RFI

RFI #: 87
 Date: 3/27/2012
 Job: EB-02 Keller Springs Lofts
 Phone: 877-777-5115

CC: Erik Earnshaw (Beeler Guest Owens Architects)
 Subject: Brick Ledge at 10" Drop in Slab

RFI #: 88
 Date: 3/27/2012
 Job: EB-02 Keller Springs Lofts
 Phone: 877-777-5115

7 SECTION
S3.04 NO SCALE

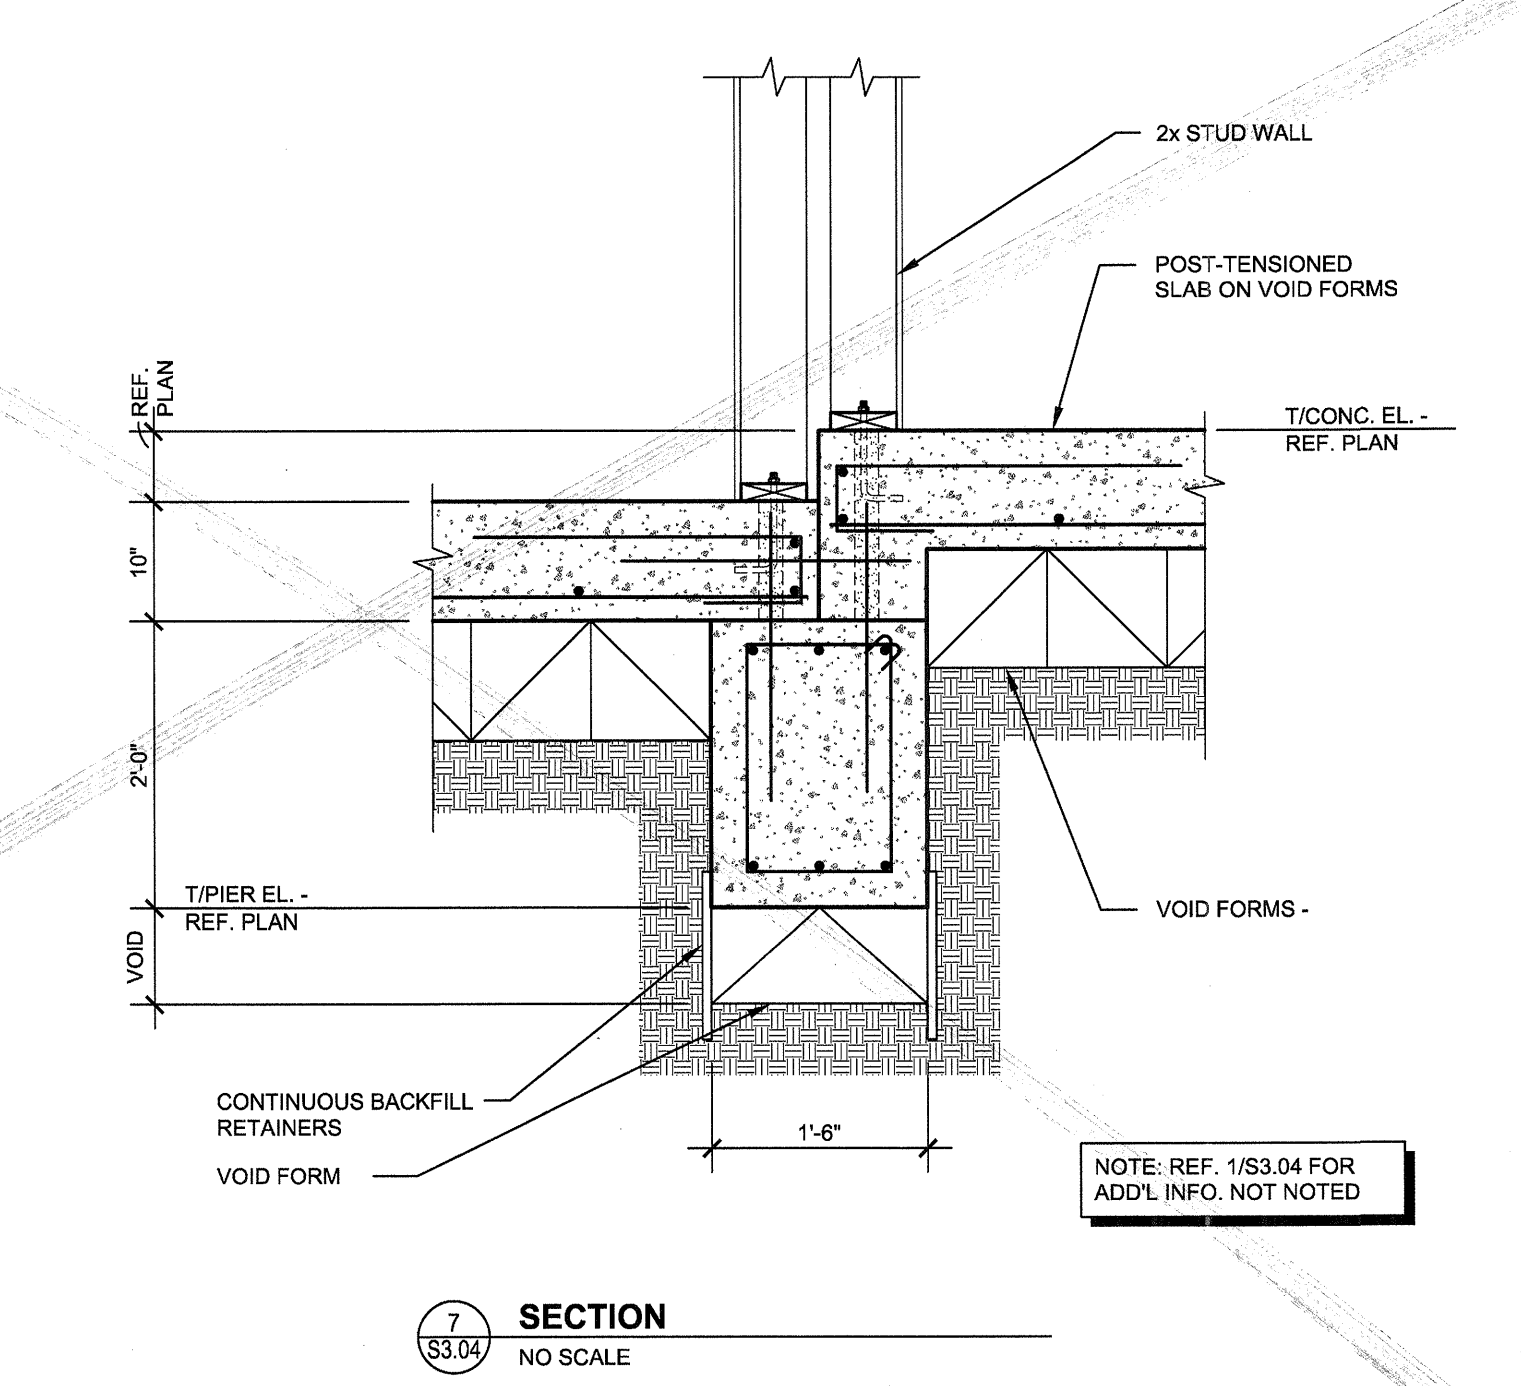
Request:
 On the left hand side of the attached drawings, please provide a blow up of the area that the brick ledge is located and the two slabs are at different elevations. How does the 3/4" gap on the back side of each wall tie into the brick ledges at different levels? See Detail 7/S3.04 that shows the air gaps behind the walls.

Response:
 I've talked with Trent Perkins about detail 7/ S3.04 and it will be revised to match my comments on the next pages of this PDF.
